City of Ryde Submission to MOD-4 (SSD-8903)
Proposal to remove additional 7 trees
IVANHOE ESTATE REDEVELOPMENT

Submission Date: 22 June 2022

Figure 3 *Trees subject to this application (outlined)*

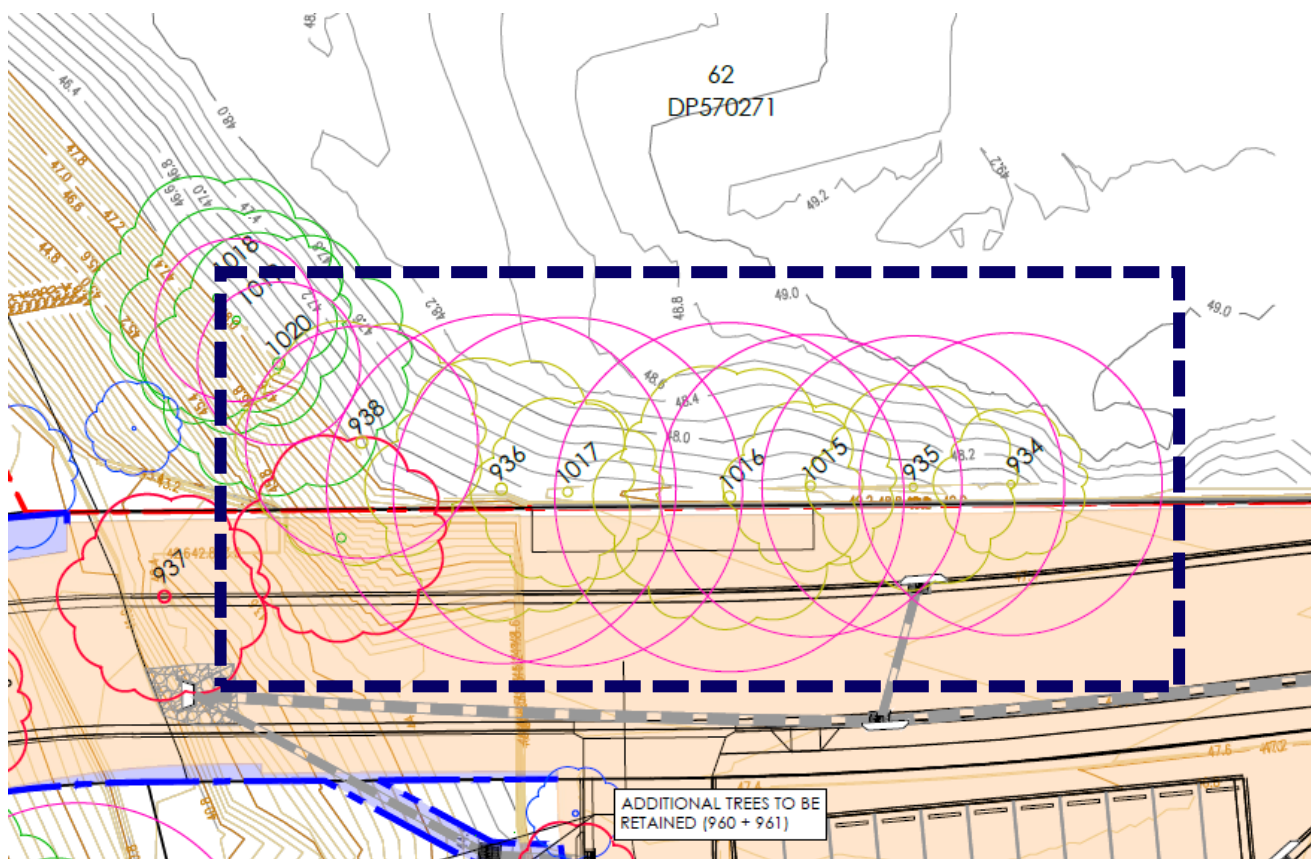
1. **Address erosion/sedimentation impact after removal:** Given the location of these trees, removal of 7 trees will leave the area open and exposed along the creek line section. Whilst the species nominated for removal are not consistent with the vegetation community of the area, recognition of their value should not be dismissed. Council requests that suitable stabilisation of the area occurs post removal of the trees. This is to minimise any sedimentation impacts in rain events or for waterway pollution and downstream sedimentation during and after the works/ machine works.

2. **Replacement trees:** It is suggested that the loss of these 7 trees be compensated by adequate replacement trees within the development area in the same vicinity for replacement of the canopy. Selection should be replaced with tree species consistent with the local area and vegetation community type. MOD 4 to include additional condition to ensure that replacement trees are planted prior to completion of this Stage of development.

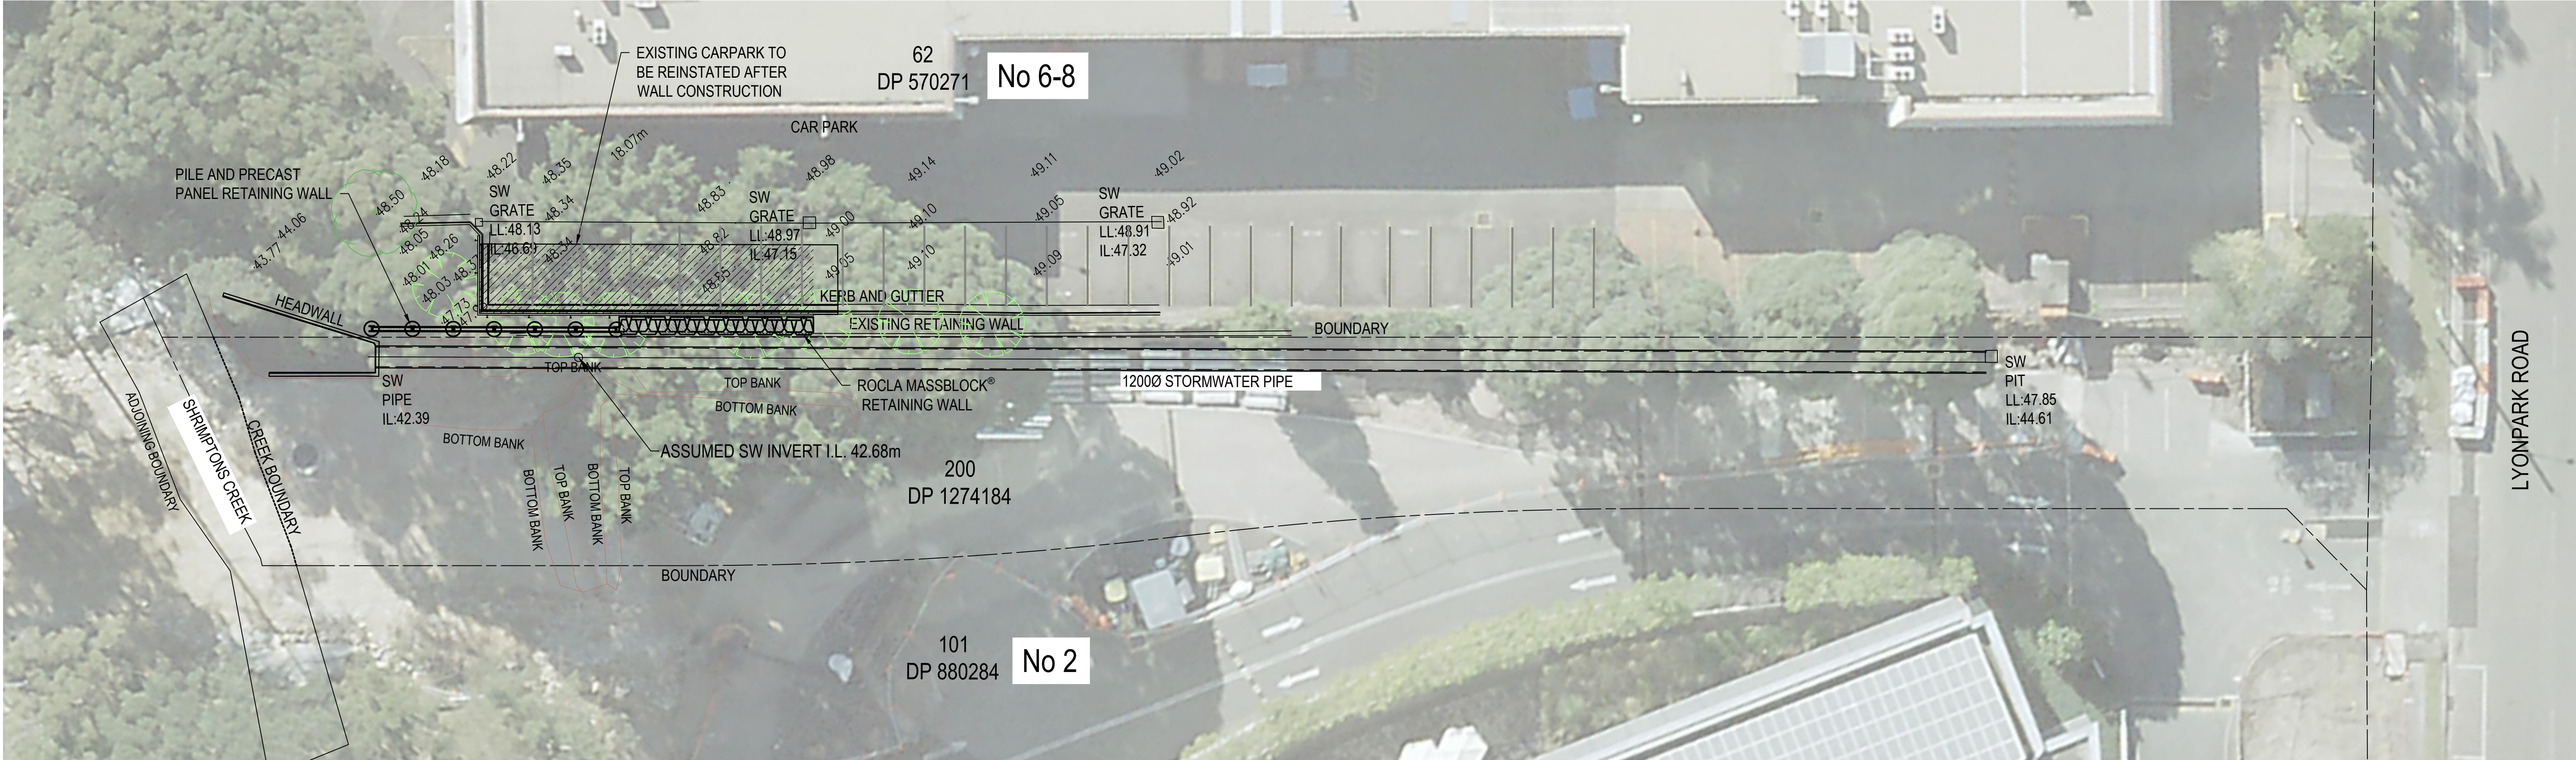
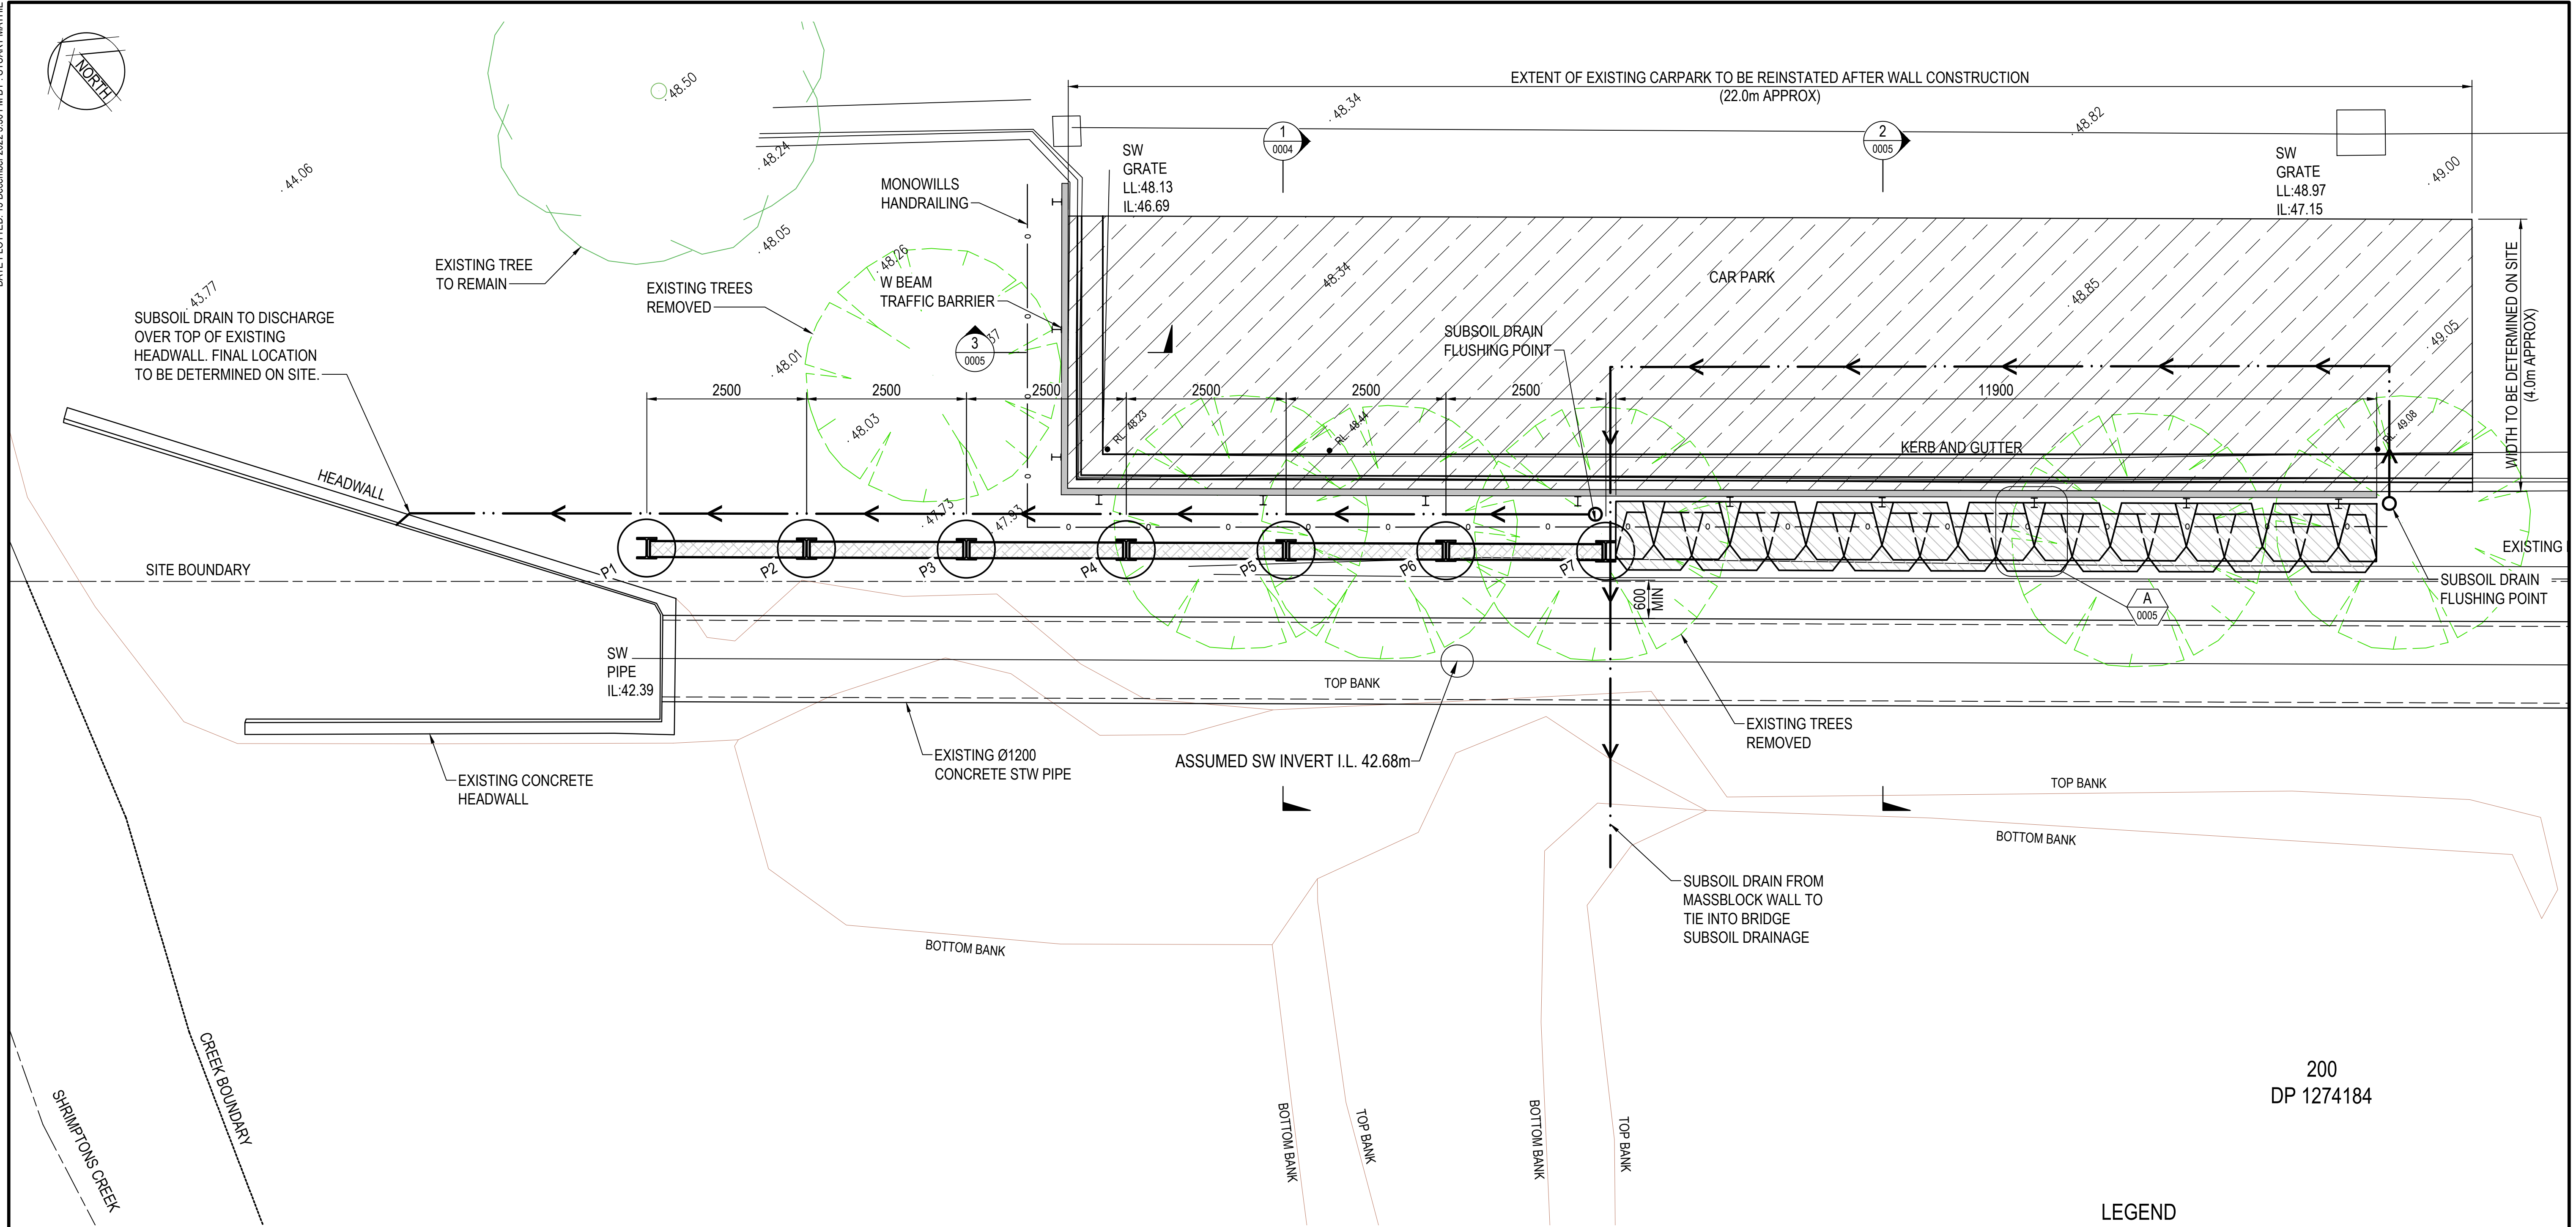
3. **Retaining Wall:** All components of the retaining wall, including subsoil drainage, must be located entirely within the private land. The subsoil drainage lines of the retaining wall must be shown on the stormwater drainage concept plan.

- Survey report by a registered surveyor.
- Geotechnical Engineers Report.
- Structure Engineers details for the retaining wall.

- Any necessary plan/documents for easement for support as part of this new retaining wall must be is to be registered with NSW Land Registry Services.
- Submit a certificate from a Structural Engineer certifying the retaining wall has been constructed in accordance with the Structural Engineers details.
- Submit a survey by a Registered Surveyor certifying that the retaining wall is wholly within the private land or any necessary easement.
- An approved balustrade may be required to be erected along the top of the wall in the interests of public safety.
